Application No: Y/36/22/HH

Site Address: Berri Court Main Road Yapton BN18 0ED

Description of works: Erection of detached workshop, gym/hobby and greenhouse. This application affects character and appearance of the Main Road/Church Road Yapton Conservation Area and a Listed Building.

Response to Y/36/22/HH

Date	Drawn	Scale	Checked
FEB 22	SR	as noted @ A1	-
Job Number	Drawing Number	Revision	
BR-497.22	-06	-

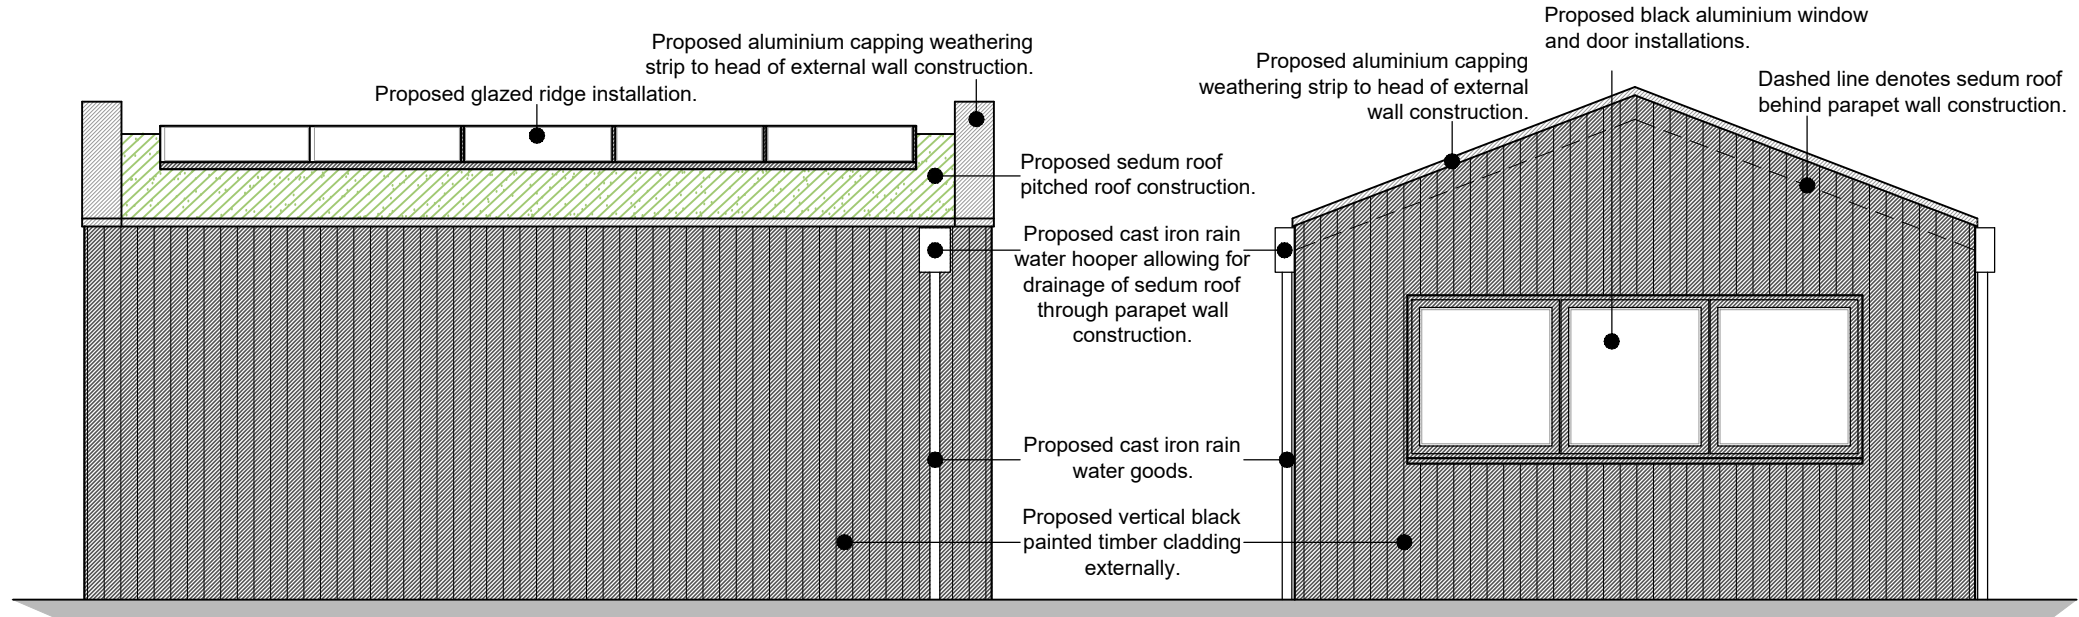
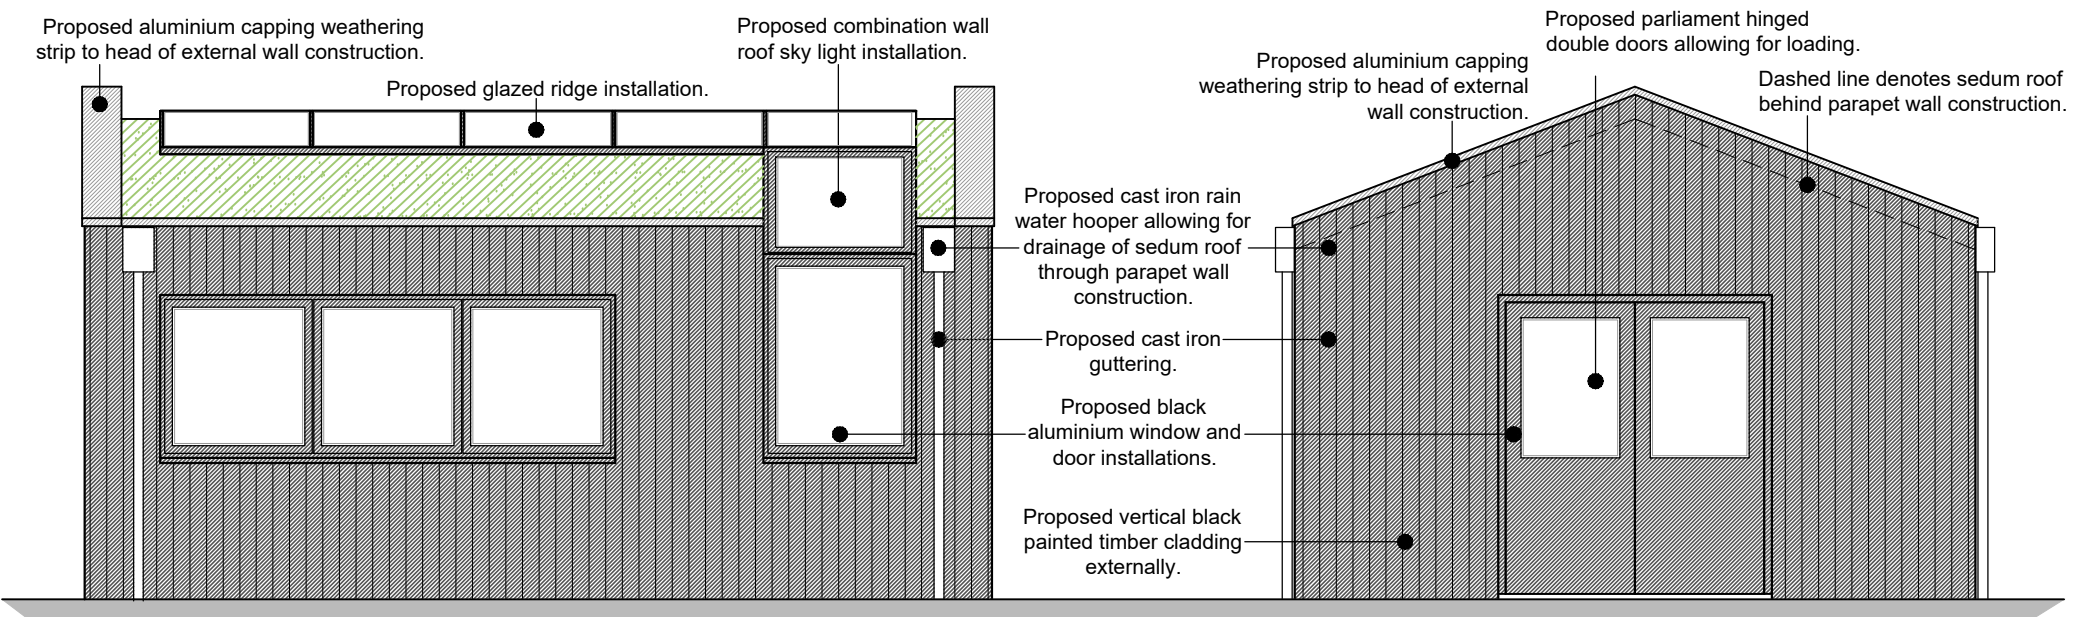
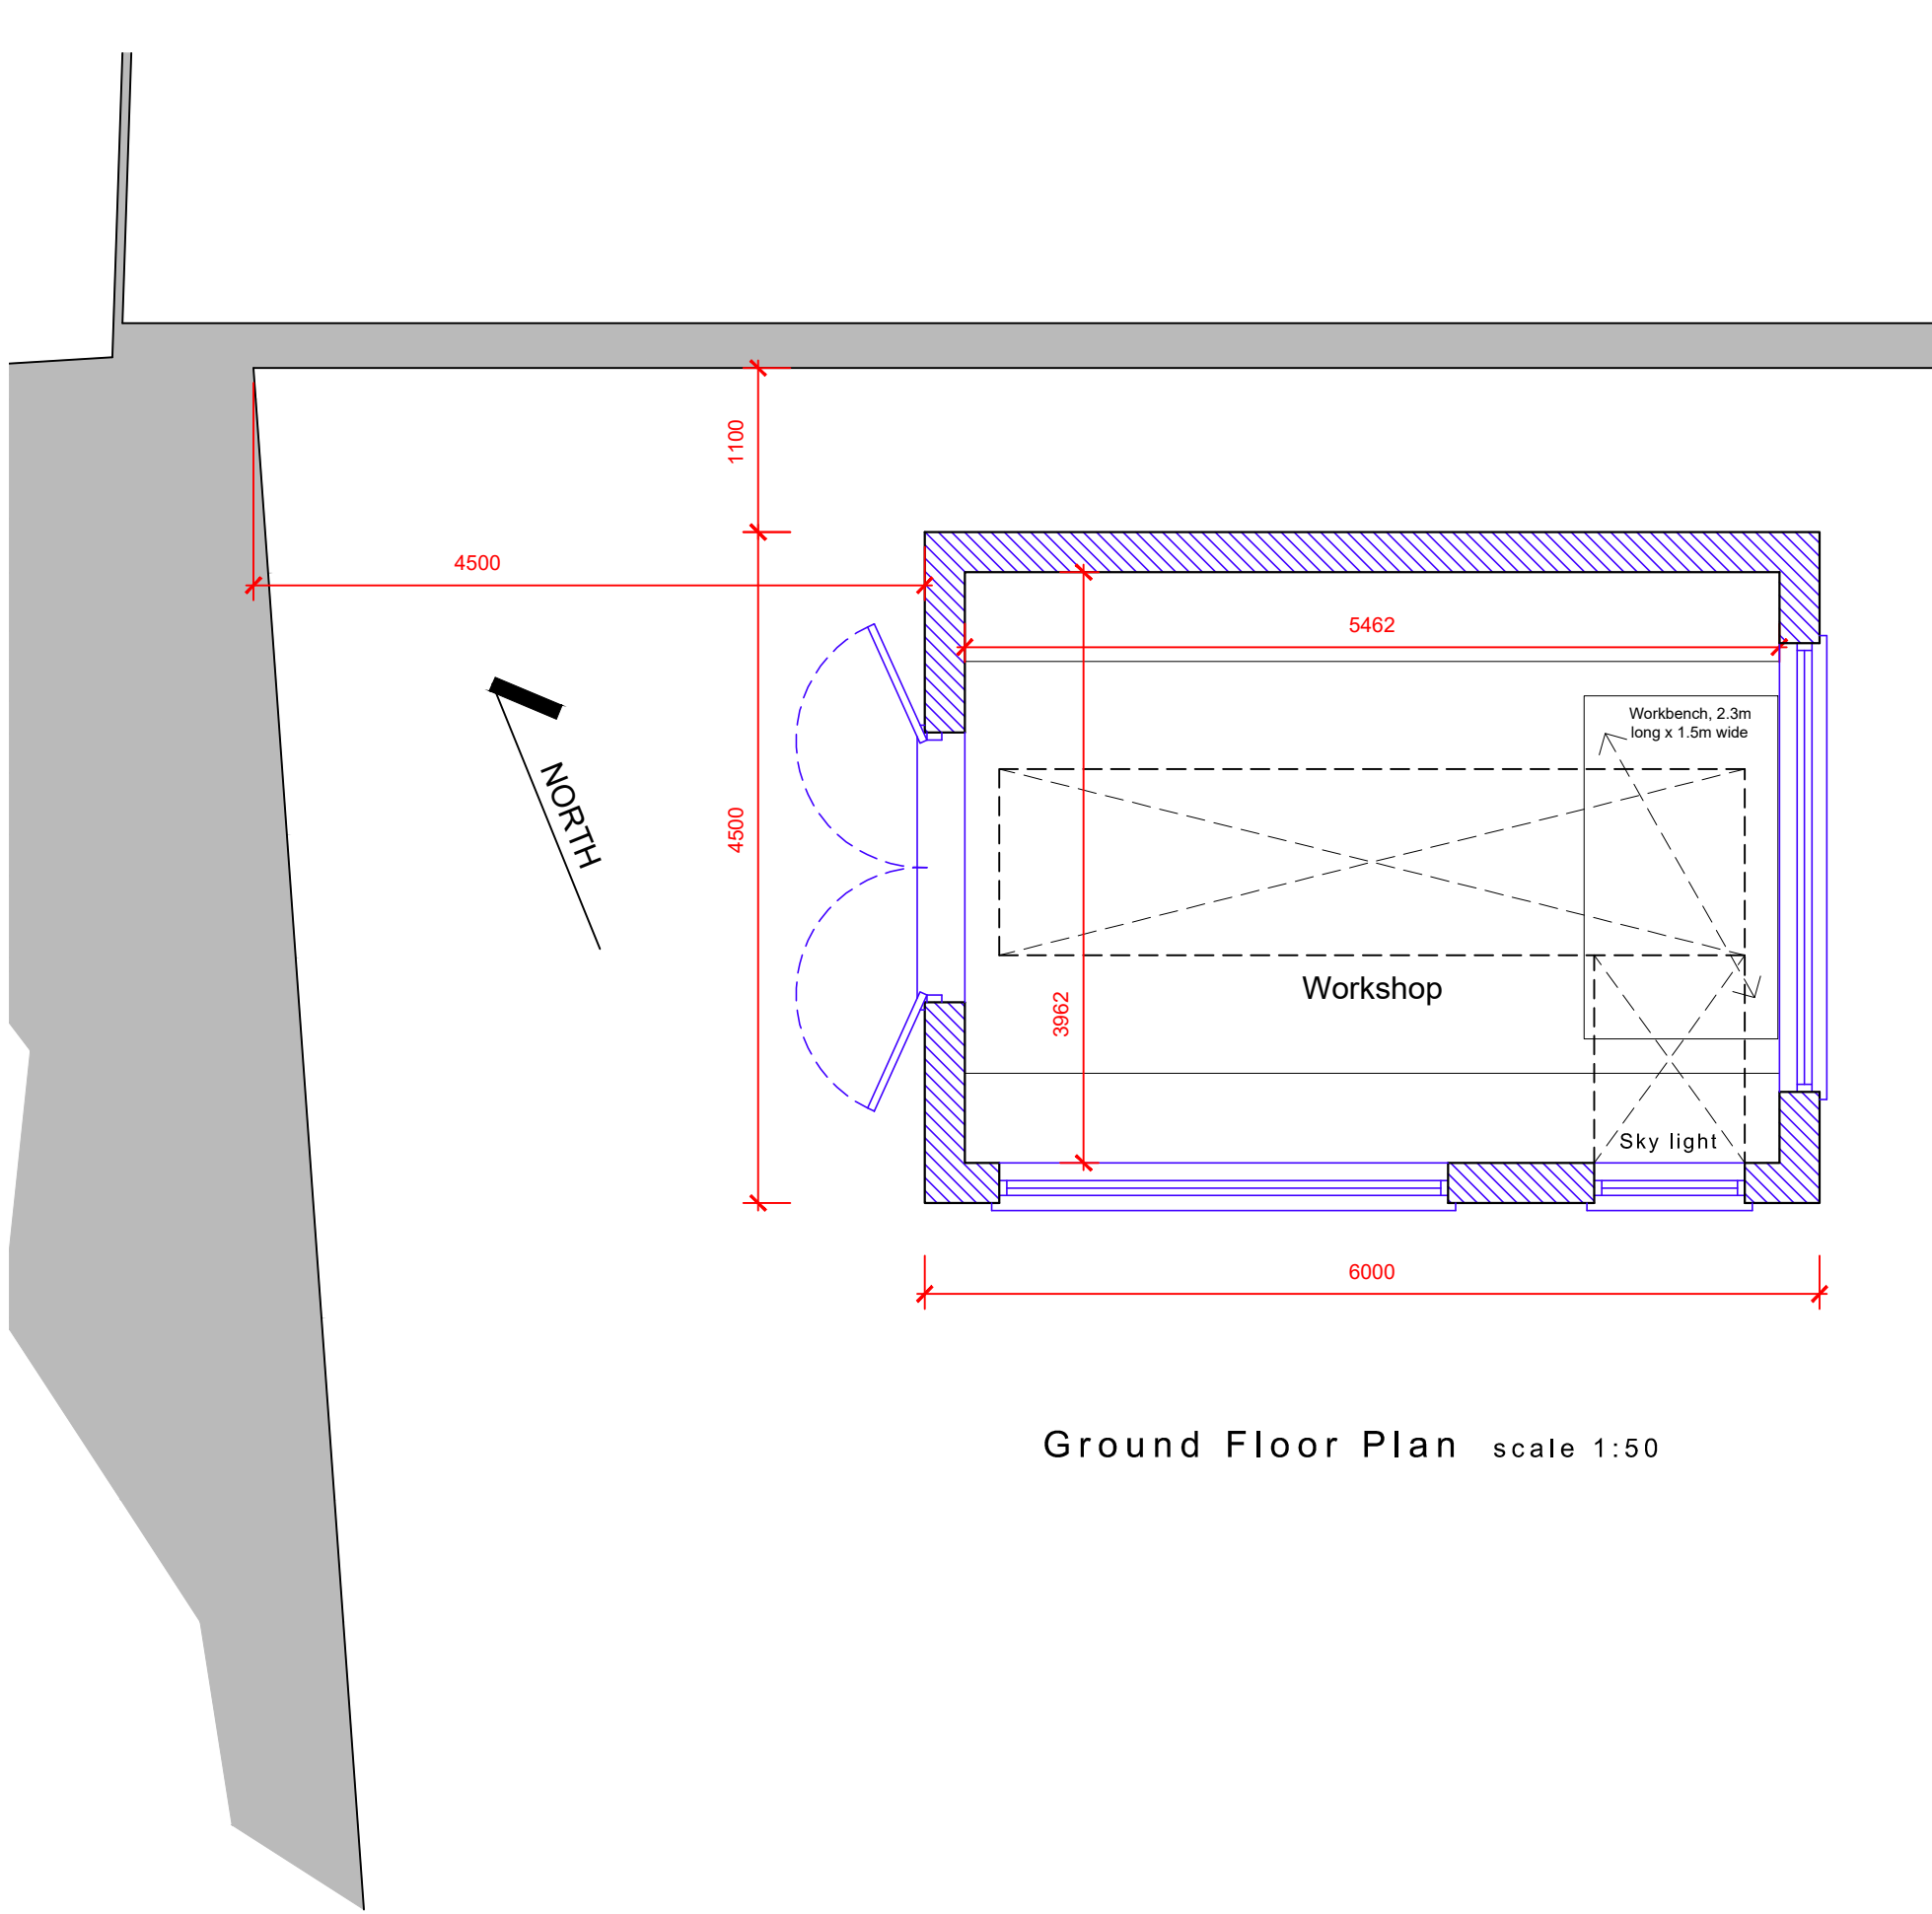
2. Proposed workshop (drawing BR/497/06) - YPC fail to understand how this structure relates to either the proposed heritage greenhouse or indeed the main listed building. YPC have concerns relating to the proximity of the proposed workshop to the main dwelling. The proposed structure jars against the listed building and has no relationship with either the proposed heritage greenhouse or indeed the listed building. YPC note that the suggested materials neither enhance or blend with the listed building or its setting and significant boundary walls. YPC object to the siting and design of the workshop.
